Development Control
Ribbles Valley Borough Council

Your ref: 2018/1105
Our ref:
Date: 27/12/2018

Re: Planning Application 18/1105

Address: Higher College Farm Lower Road Longridge PR3 2YY

Drawing file: planx_downloads / 18_1105_Proposed_Access.pdf

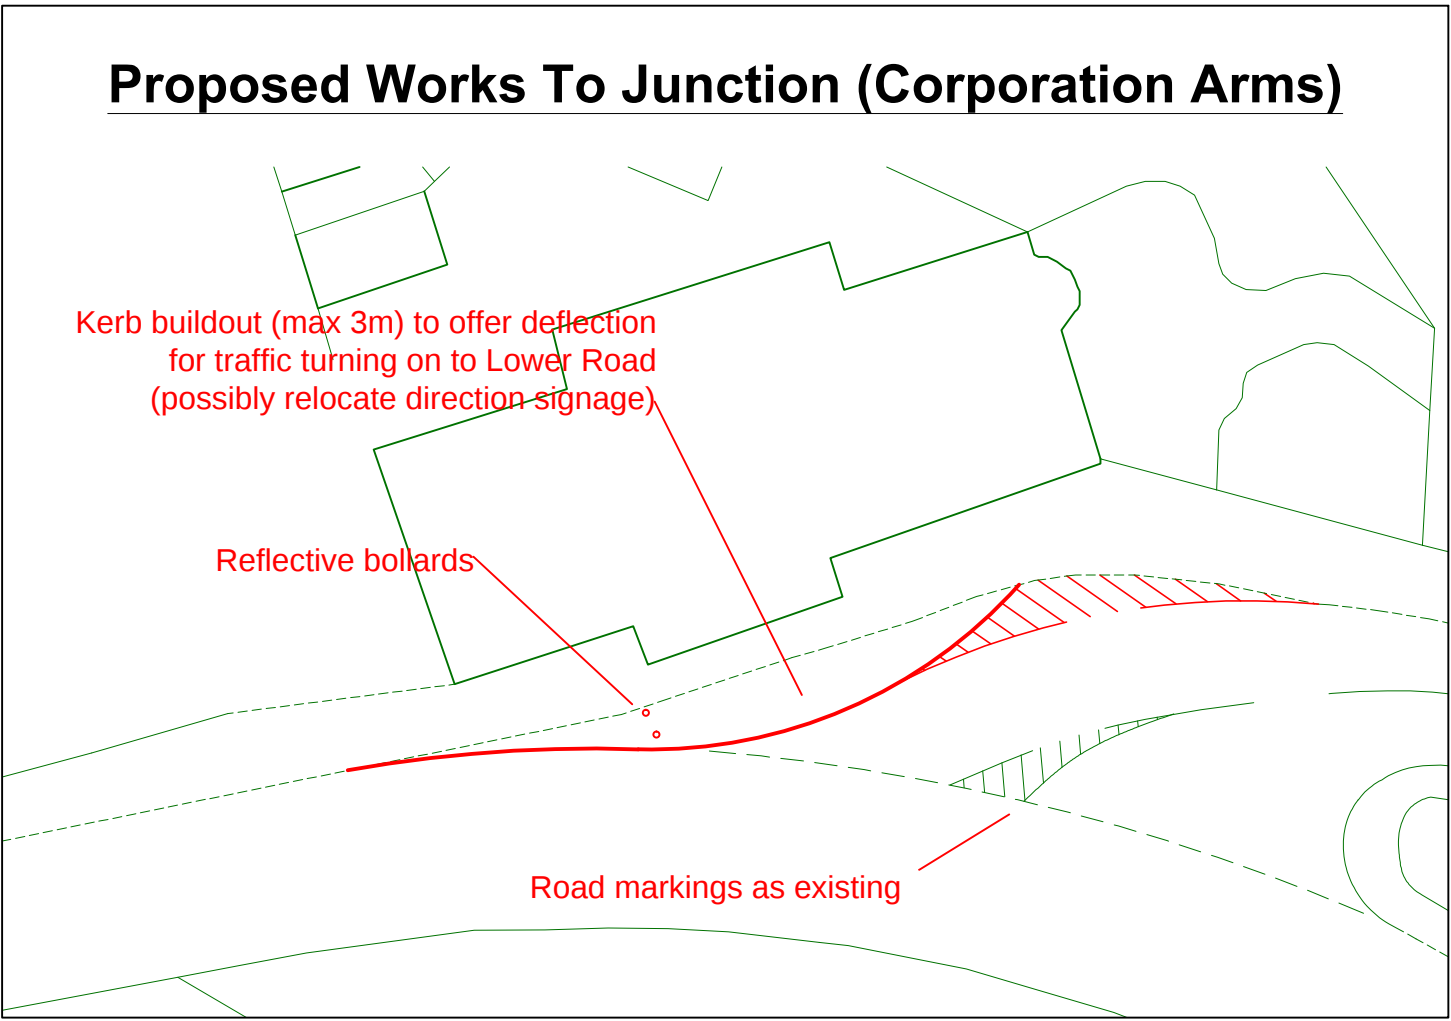
There are however a number of concerns regarding the self build elements of the development which would require some further information and some conditions relating to the timing of the works required to form the new access and associated infrastructure. It is noted that the plans showing the expected entrance do not show the bus stop approximately opposite the new access that is to be formed. It is also expected that the new junction and access road are to be substantially completed prior to the commencement of any building works, as it is not expected that the plots will be sold and developed in a similar manner to a conventional housing development.

In order to ensure that the estate road and its junction are satisfactorily completed we would look for the new junction to be completed prior to any construction works being carried out on the first plot being sold and the entire estate road being complete to base level within 6 months of the plots commencement of construction works, this shall include the provision of a footway for the full perimeter of the turning head.

In order to fully support the application we would look for a plan showing the swept path analysis for a large articulated heavy goods vehicle at the junction of Lower Road B6243 and Preston Road B6245. The vehicle shall be shown completing all the expected turning movements accounting for the new build out.

4. The new estate road for the approved development shall be constructed in accordance with the Lancashire County Council Specification for Construction of Estate Roads to at least base course level up to the turning head, the turning head shall include a constructed footway around the turning head. **Reasons:** To ensure that satisfactory access is provided to the site before the development hereby permitted becomes operative.

5. No part of the development hereby approved shall commence until a scheme for the construction of the site access and the off-site works of highway improvement has been submitted to, approved by, the Local Planning Authority in consultation with the Highway Authority as part of a section 278 agreement, under the Highways Act 1980 and these works shall be completed prior to the commencement of any building works. **Reasons:** In order to satisfy the Local Planning and Highway Authorities that the final details of the highway scheme/works are acceptable before work commences on site and to enable all construction traffic to enter and leave the premises in a safe manner without causing a hazard to other road users.
